**WEST SUSSEX COUNTY COUNCIL
STRATEGIC PLANNING CONSULTATION**

TO: Arun District Council
FAO: Peter Cleveland

SUBJECT: BR/140/14/PL -Conversion of existing vacant listed building to provide 4No. flats.
Demolition of single storey building at rear (north) and construction of single storey extension and
separate 2 storey building to provide 5No. flats. Resubmission following BR/41/14.

12, Chichester Road, Bognor Regis, West Sussex

CLIENT
CS PROPERTY AND CONSULTANCY LTD
 PROJECT
MANOR HOUSE, 12 CHICHESTER ROAD
BOGNOR REGIS PO21 2XE
 DRAWING TITLE
PROPOSED GROUND FLOOR PLAN
 SCALE
1/100 at A3
 REFERENCE
11332.11B

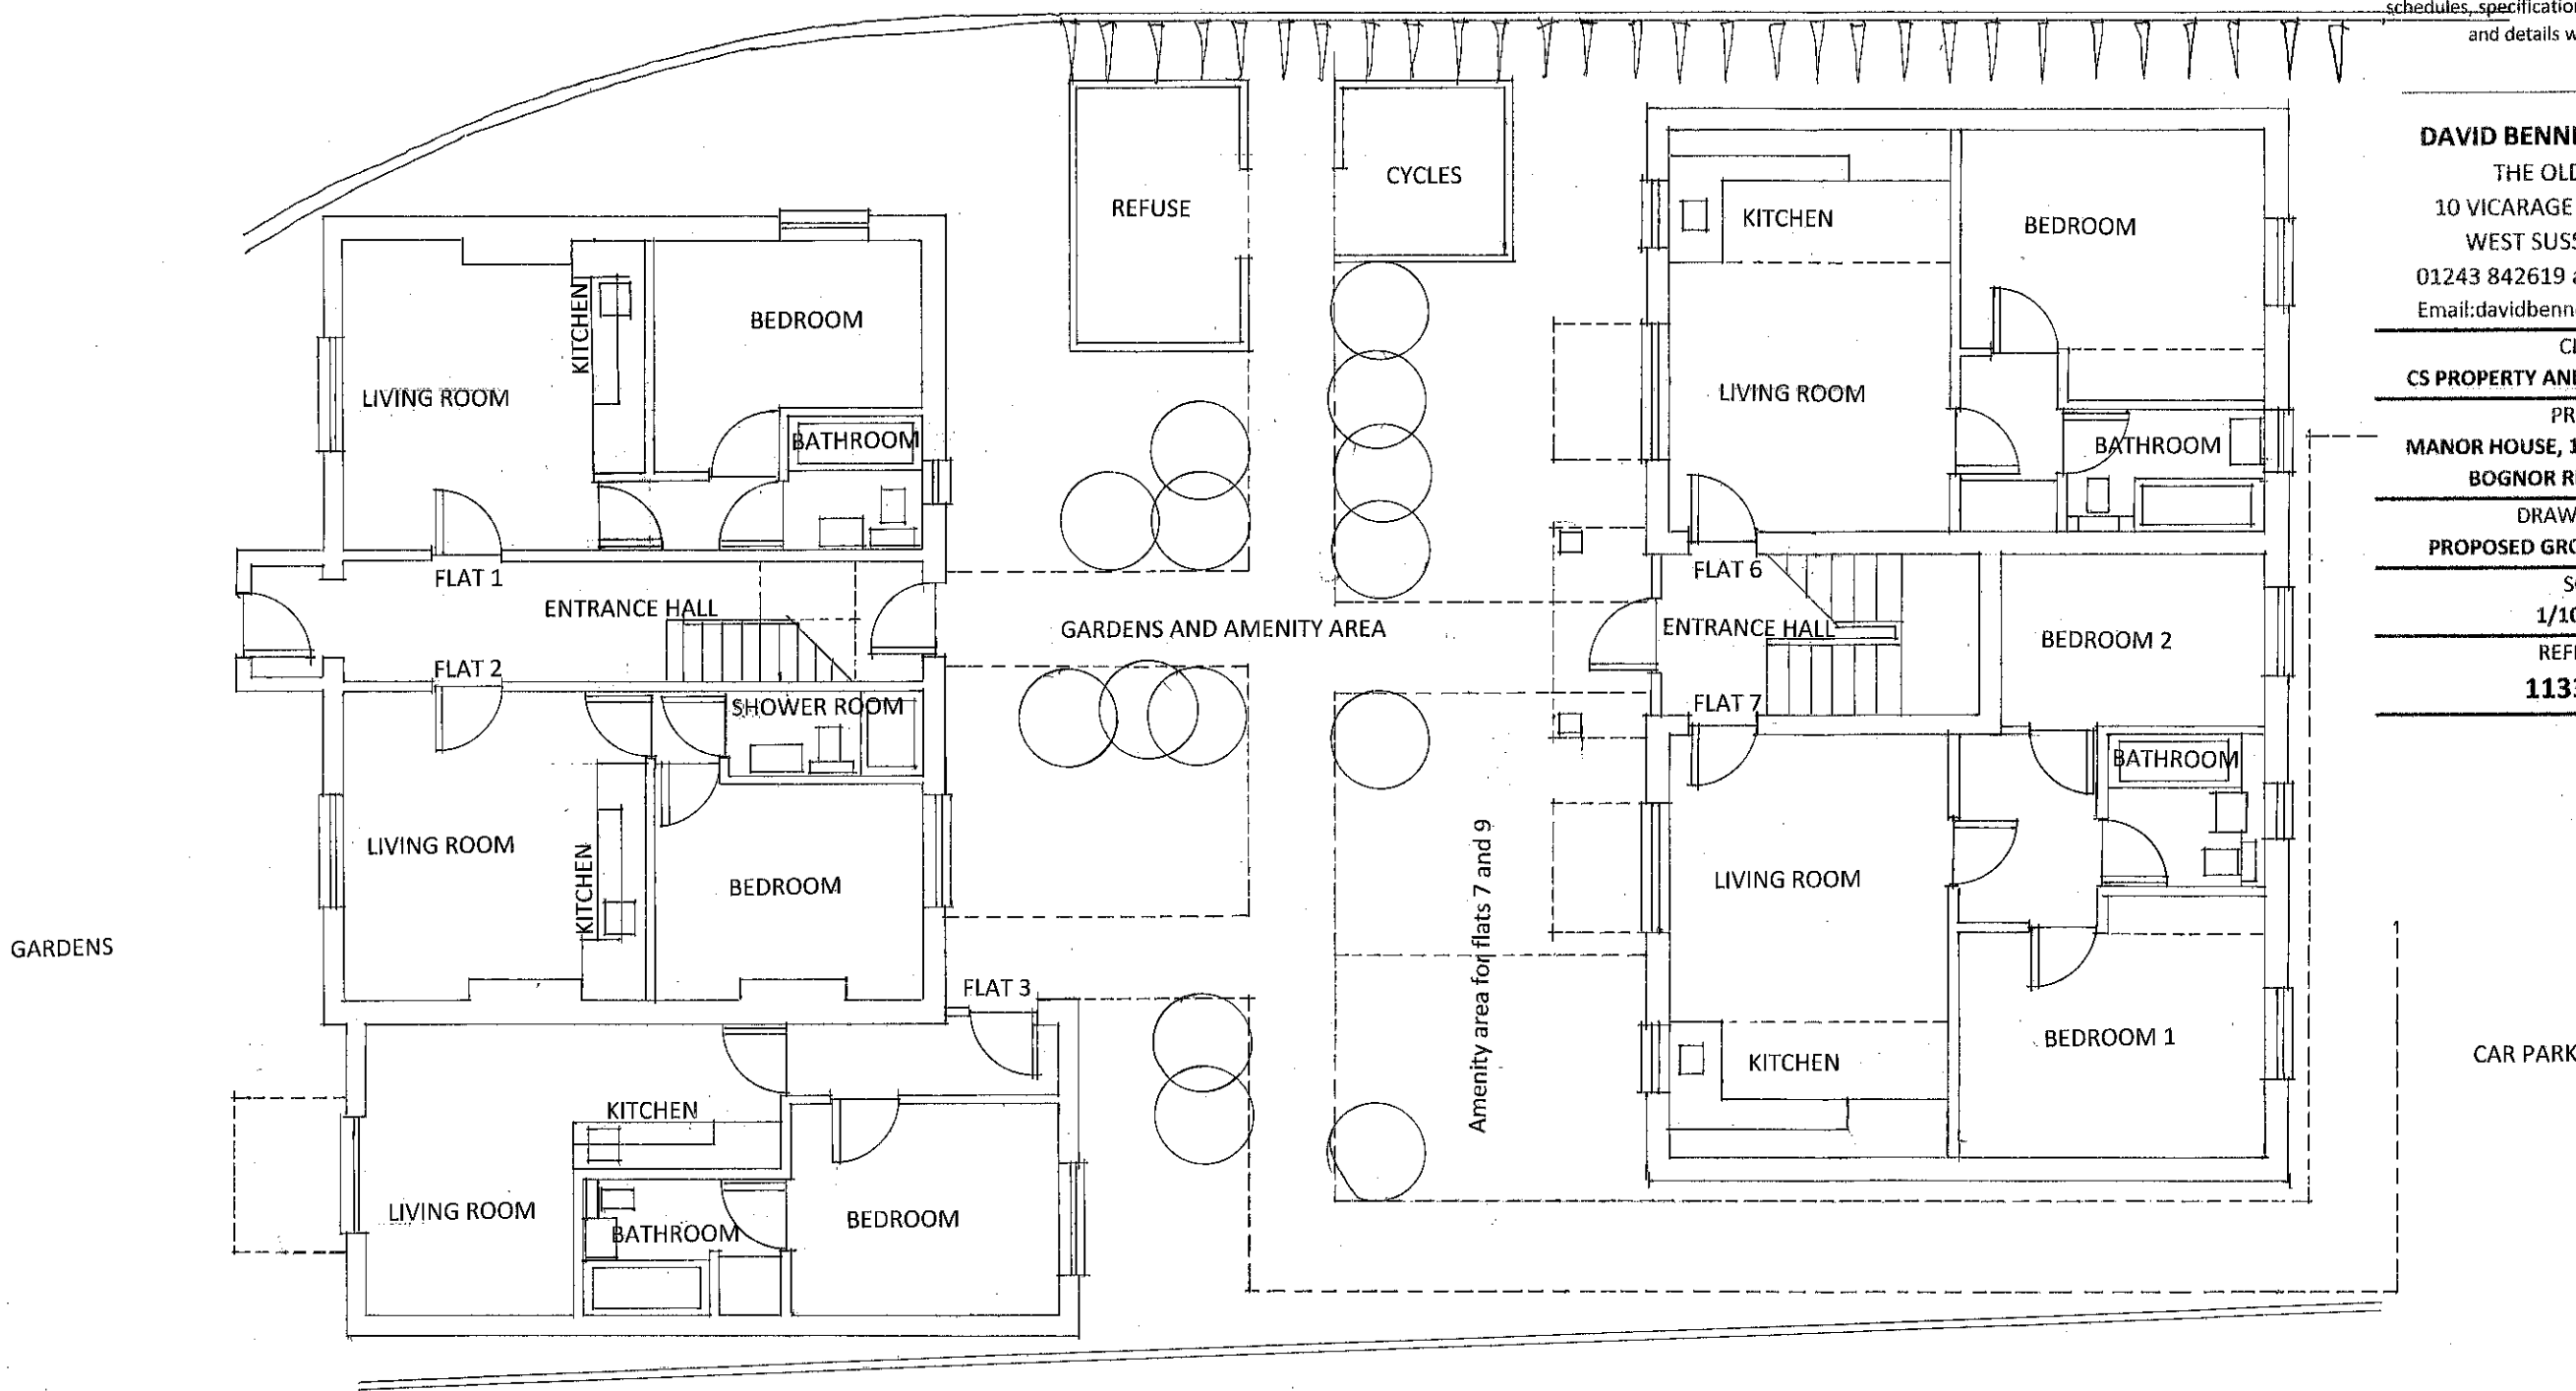
A total of 10 car parking spaces will be provided on site. This provision has been considered against the WSCC Parking Demand Calculator. The proposed provision does not exceed the requirement generated by way of the PDC. In terms of parking layout I would advise that the applicant re-considers the location of the two parking spaces along the access road, whilst it is appreciated that this is a low speed environment, there is the potential for conflict with vehicles entering the parking area along the access road.

There has been no indication of whether refuse collection will take place from within the site or from the access point onto Gordon Avenue. The constraints of the site would not make a workable turn on site facility for larger vehicles feasible. Therefore it is advised a communal bin store is placed at the access point onto Gordon Avenue. The waste collection authority should be consulted to obtain their views on the suitability of this arrangement from their point of view however.
